# CITY OF ALBUQUERQUE

April 1, 2011

**Re: Valero Corner Store, Unser and McMahon  
Grading and Drainage Plan and Report  
Engineer's Stamp dated 3-21-11 (A11/D007D)**

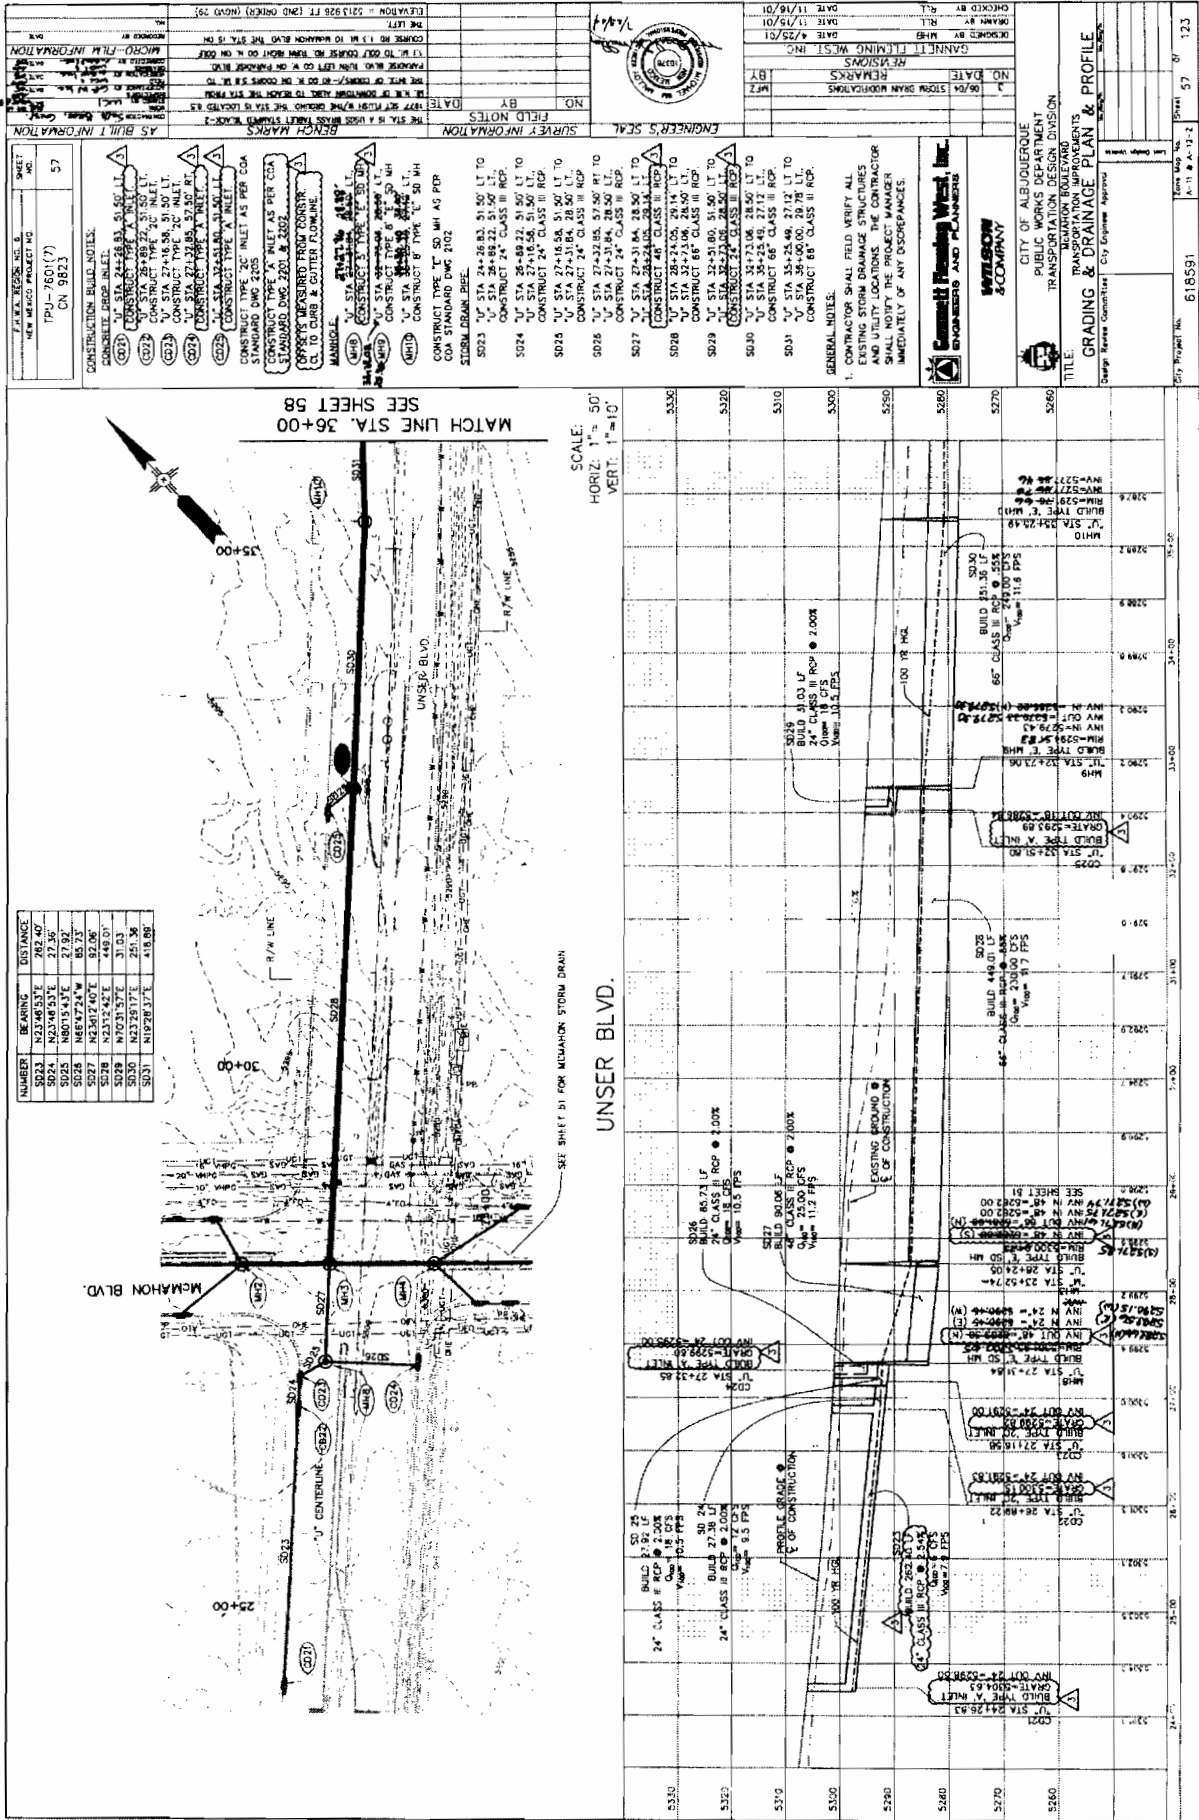
- The Type "E" MH located at the North East corner should be built with the Work Order for Calle Perro Road.

Hydrology is requesting that proposed landscape areas be depressed to retain/infiltrate the rain that falls on them.
